AT 75 Market St. 028 K003001

**Proposed Project Description:**  
Remove existing handicap lift & replace with a new handicap ramp in lobby

**City of Portland, Maine - Building or Use Permit**

ACCESSIBLE RAMP FLOOR PLAN  
SCALE: 1/2"=1'-0"

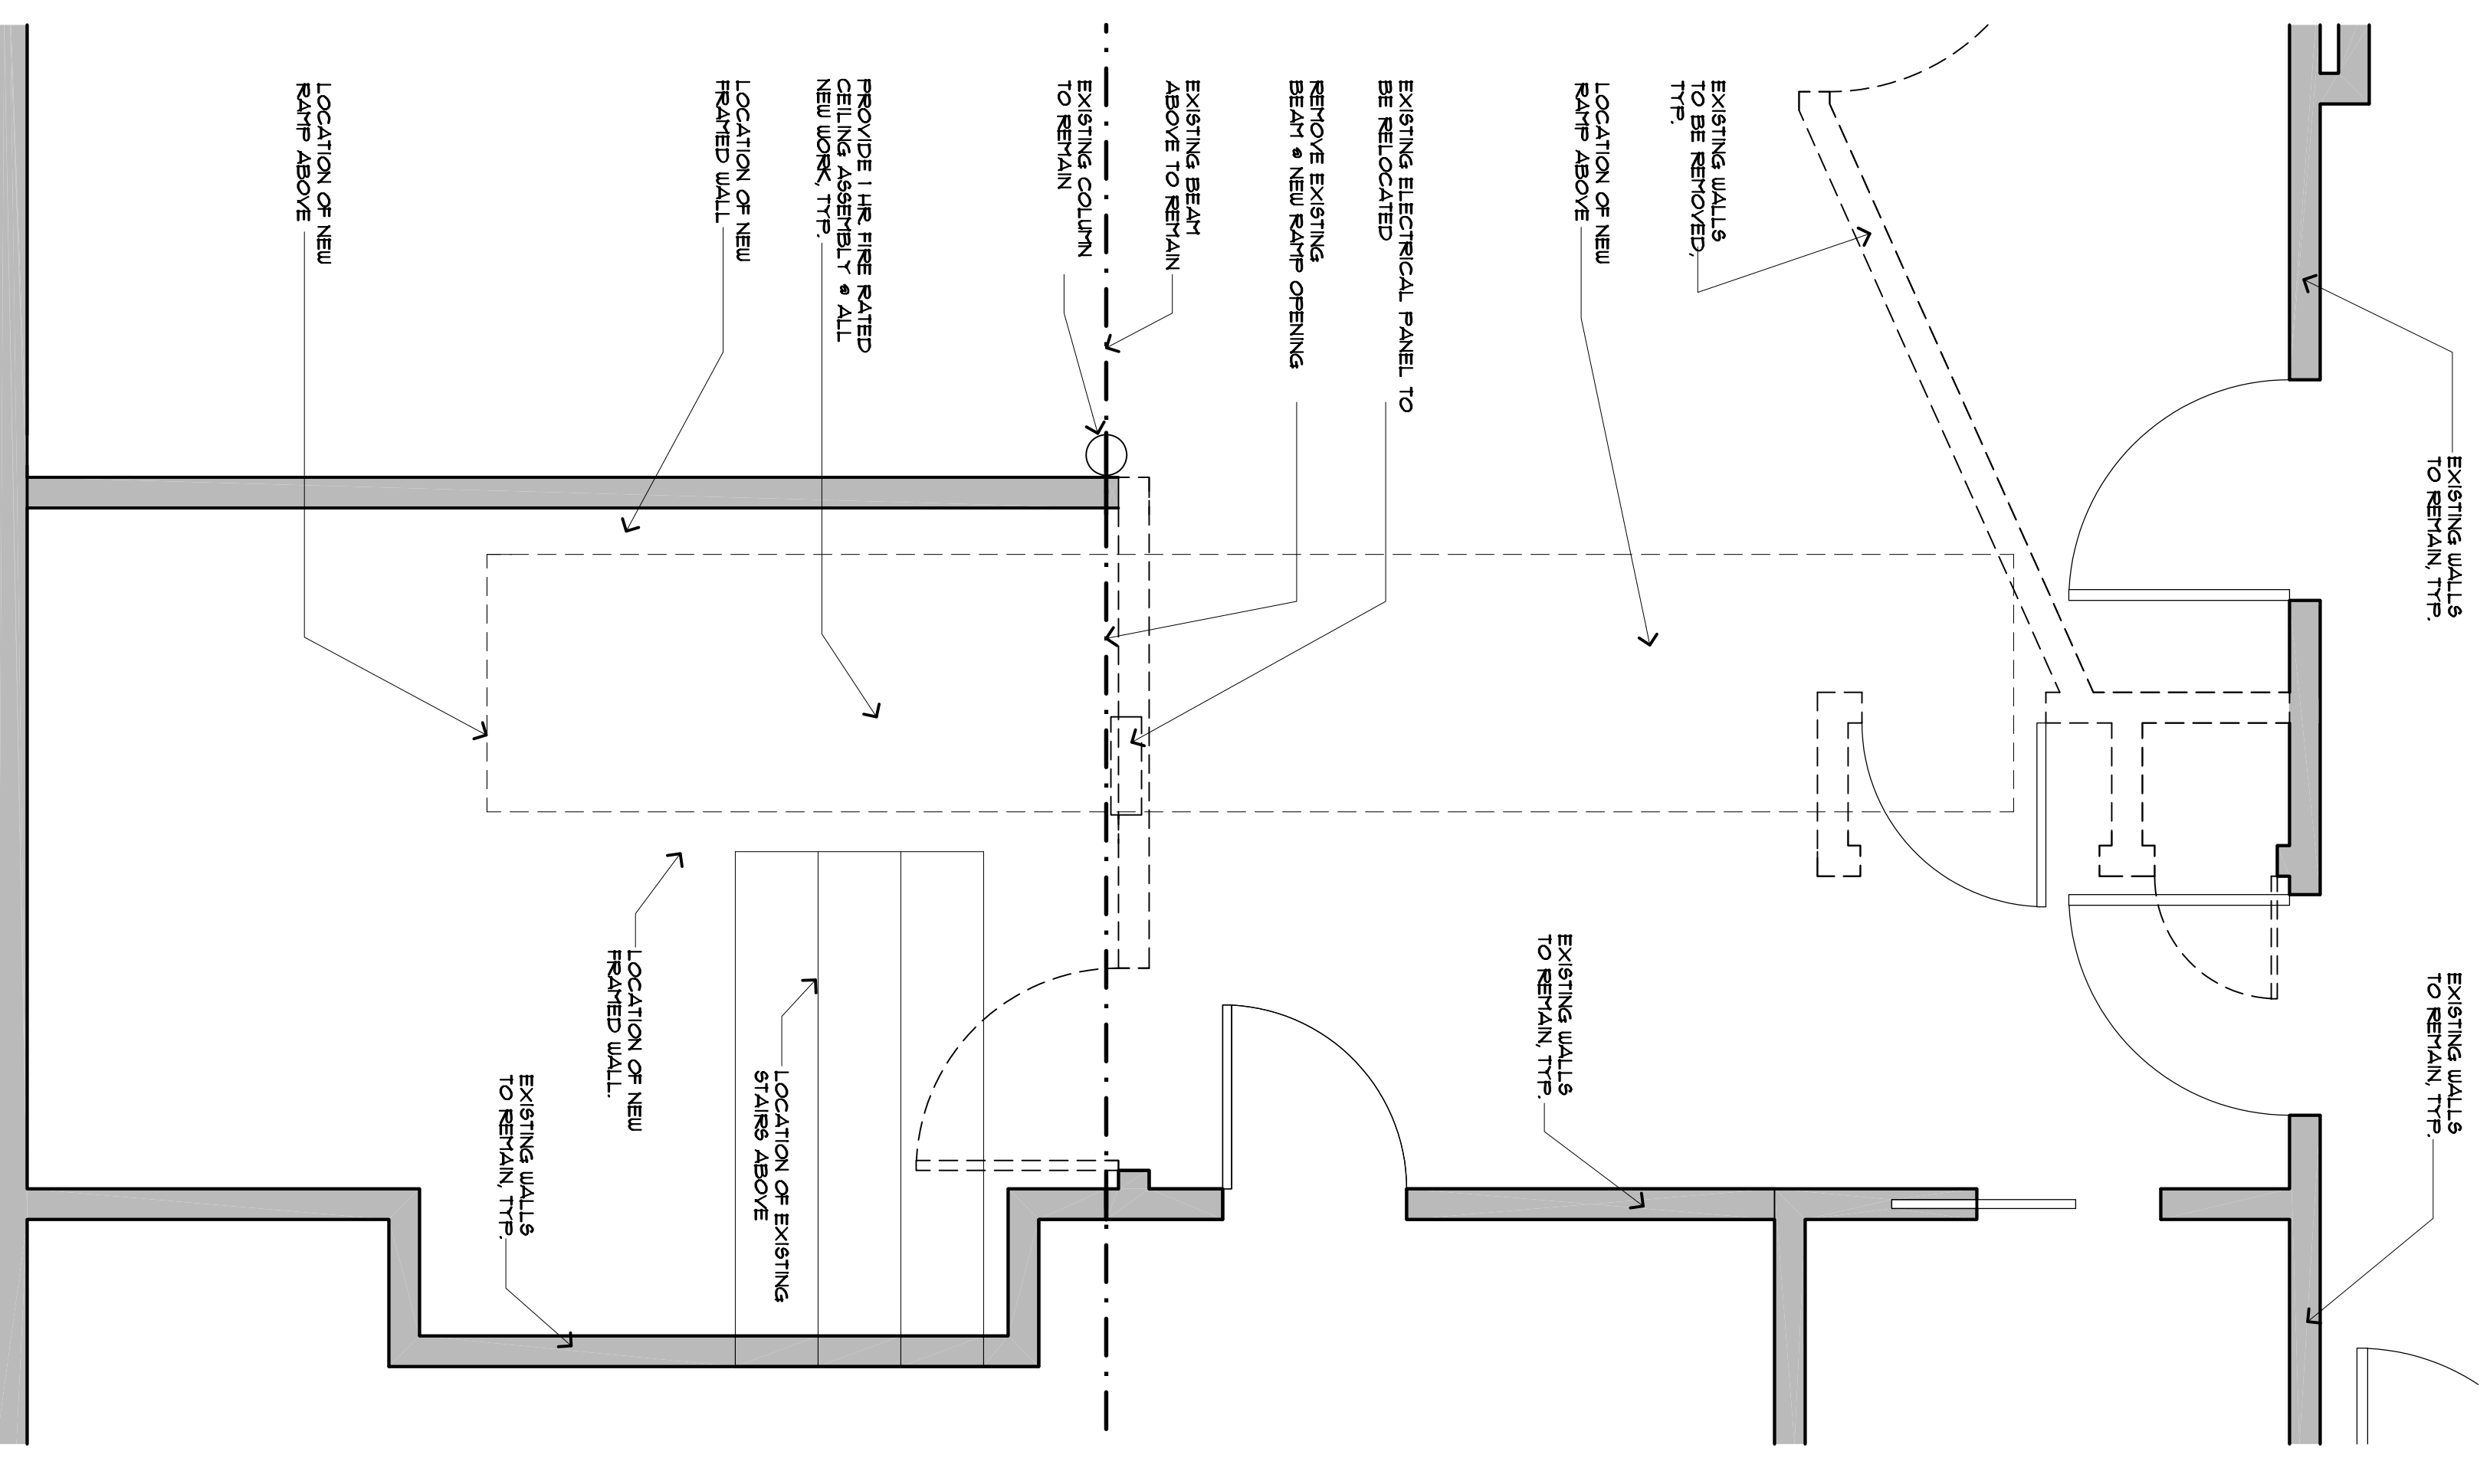
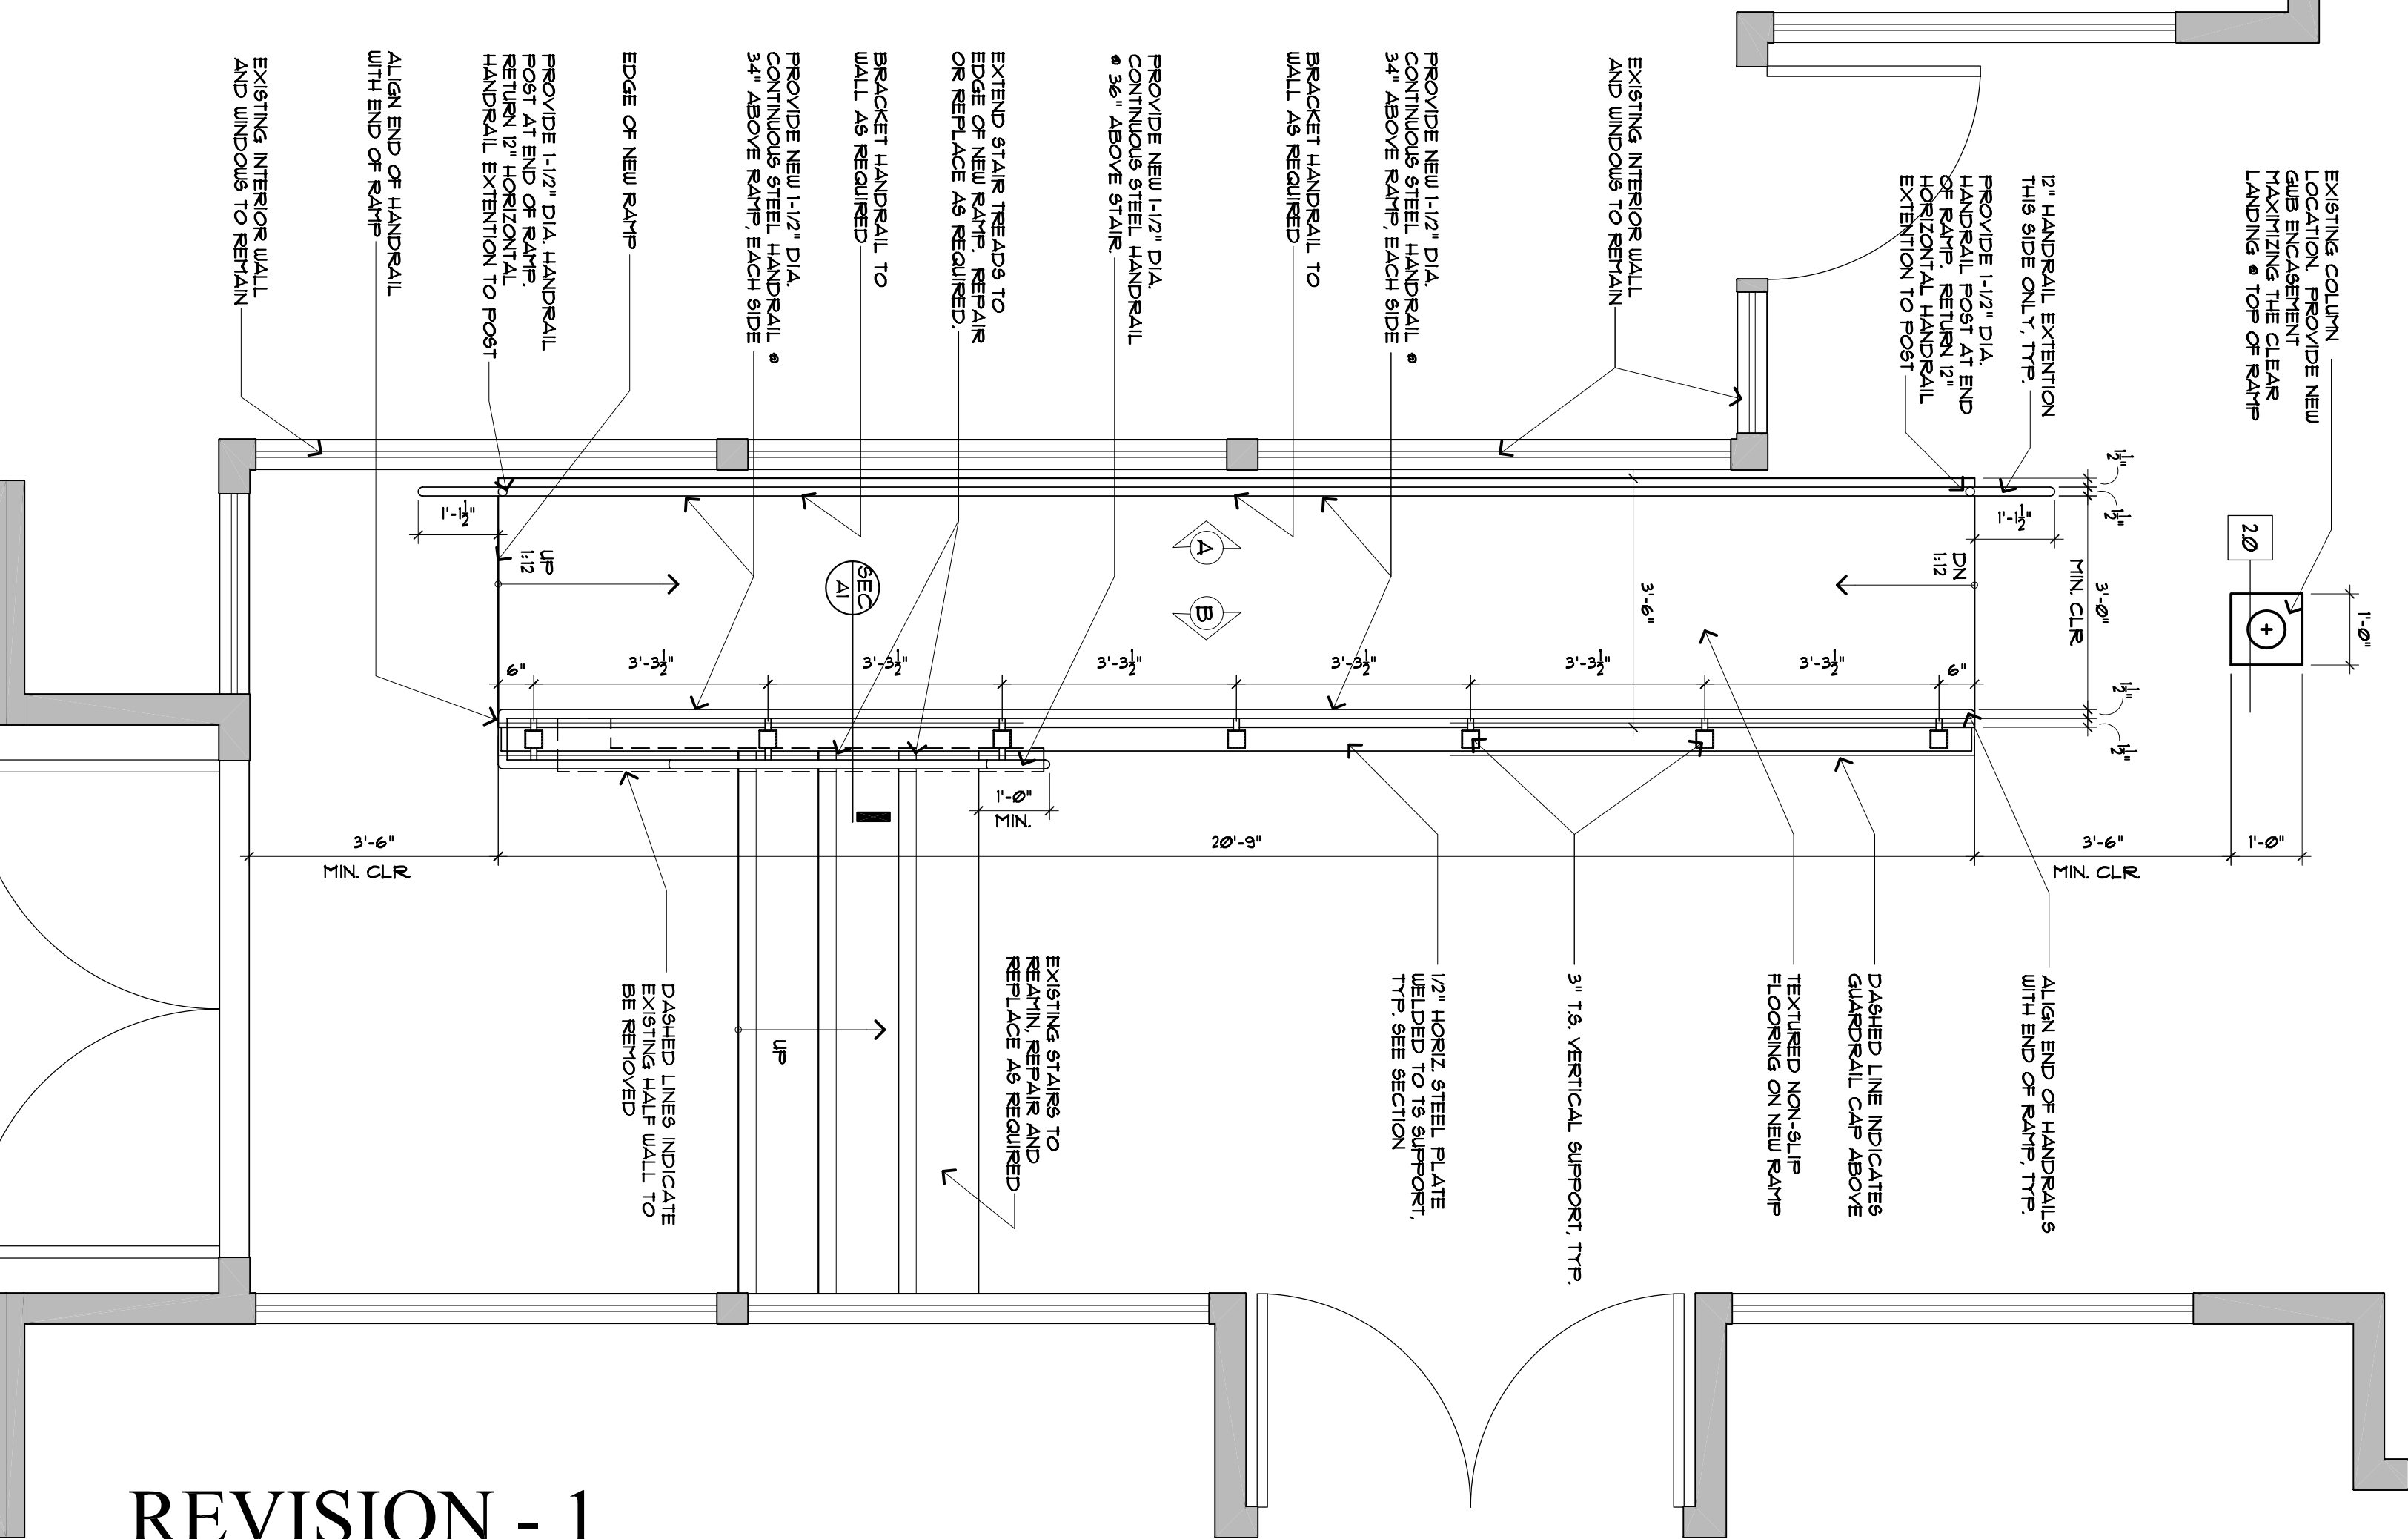
1) The initial permit is for Demo and exploratory work. Structural plans must be submitted and approved prior to framing.

4/26/2005-mjn: need better structurals, Emailed Architect and advised the builder
